**From:** Peter Johnston <Peter.Johnston@shoalhaven.nsw.gov.au>  
**Sent:** Friday, 4 September 2020 4:40 PM  
**To:** Dimitri Gotsis  
**Cc:** Ljupco Lazarevski; Matthew Kidd; Cathy Bern  
**Subject:** SSD - 8845345 - Response to request for input into SEARs for Budawang School for Specific Purposes

The Department of Planning, Industry and Environment has received a request for Secretary's Environmental Assessment Requirements (SEARs) for the Budawang School for Specific Purposes (SSD-8845345). The proposed development is a State Significant Development under the *Environmental Planning and Assessment Act 1979*.

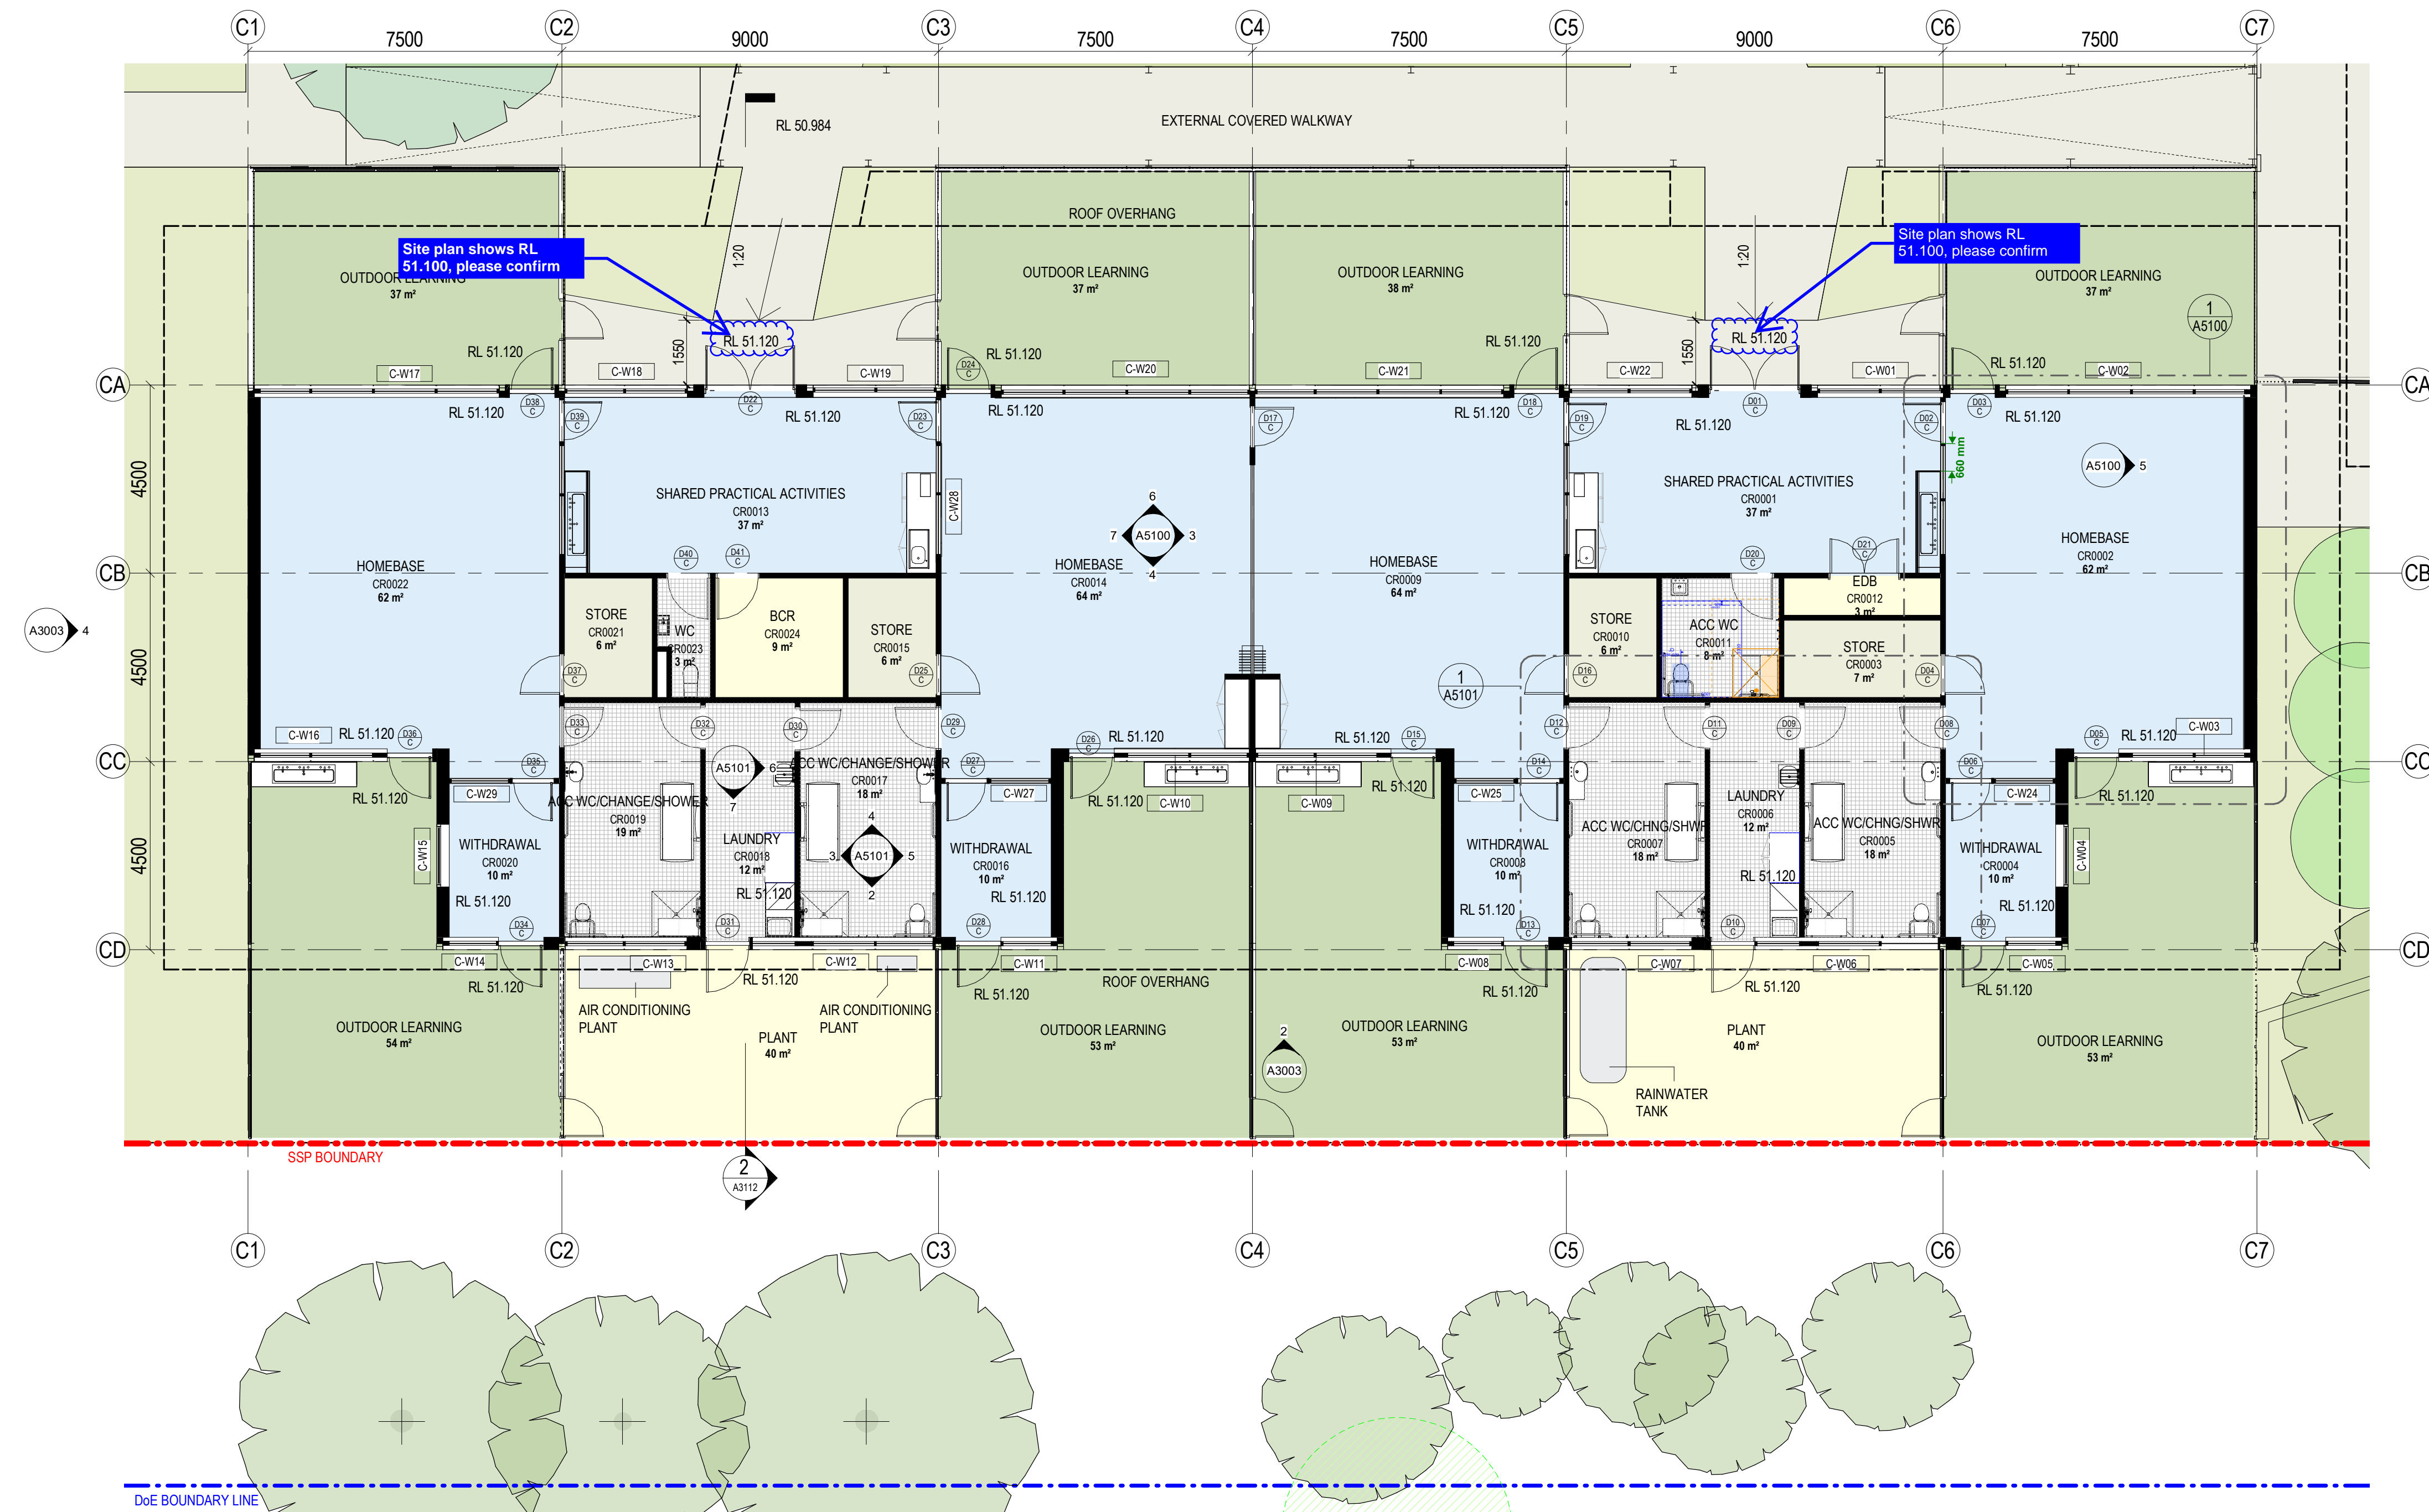
1. The applicant is made aware that there is an existing DN225 AC/C Sewer Rising (Pressure) Main located within an Easement to Pump Sewage that diagonally traverses the property. No building or part thereof shall be constructed within this easement. Proposed Block A1 has a corner located on the easement boundary line. It is preferred for the applicant to move the building clear of the zone of influence.
2. Detailed survey by registered surveyor showing the location and depth of the existing DN225 AC/C Sewer Rising (Pressure) Main is to be undertaken to ensure any infrastructure located over/near the sewer asset (eg, road works/ parking areas, structures (eg, gates), buildings, hard stand areas, landscaping, etc) comply with all of Shoalhaven Water's Specifications and Council's policies (eg Building Over Sewer policy). The

applicant is advised that consideration needs to be given to the relocation of the sewerage rising main clear of the proposed development (including the sewer easement) may need to be undertaken.
